C. Christian Berg, PE
Structural Engineer

May 7, 2020

Re: 2435 Neils Creek Drive, Lillington, NC

CLG. JOIST FRAMING PLAN
THE FOXCROFTE

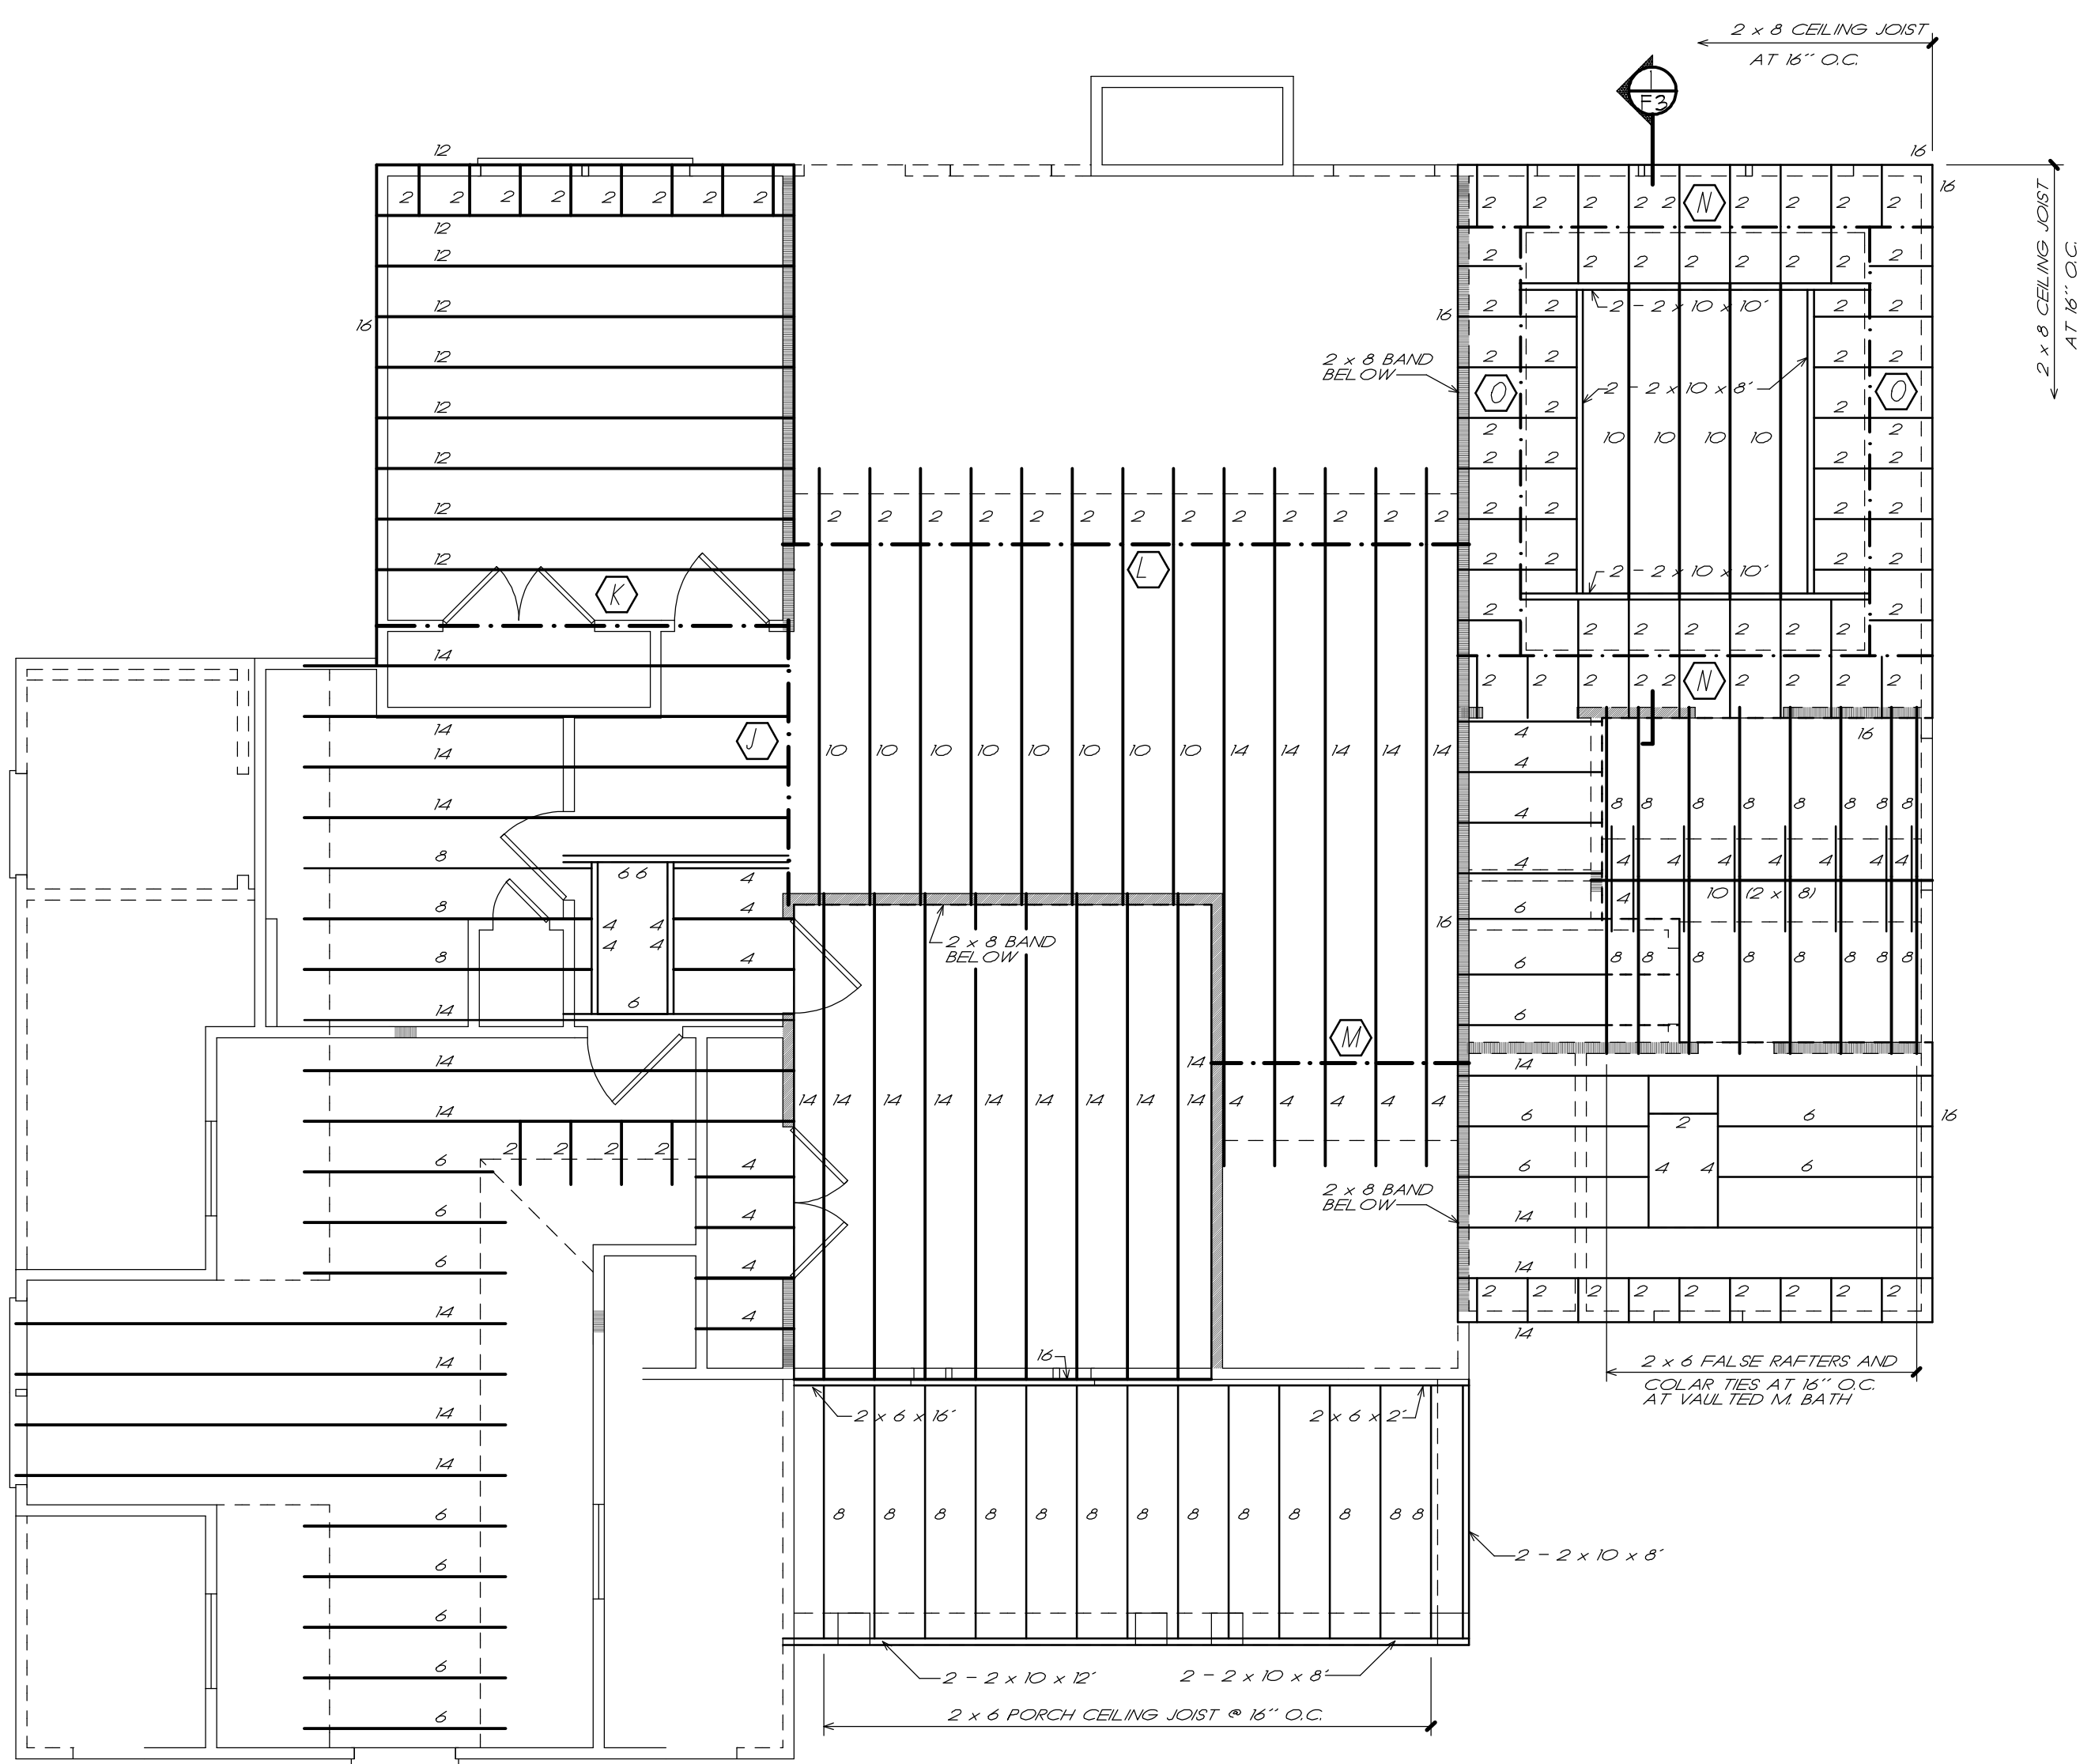
- The ceiling joists in the master bedroom have been installed in the opposite direction from shown on the original plans (due to deletion of the proposed tray ceiling). This is acceptable as installed
- The balloon framed gable end studs, which are 2x4@16" o.c., extend up to 16' high at the cable (which exceed their allowable length). To correct this, all of the studs on the gable ends which exceed 12' in height should be doubled.
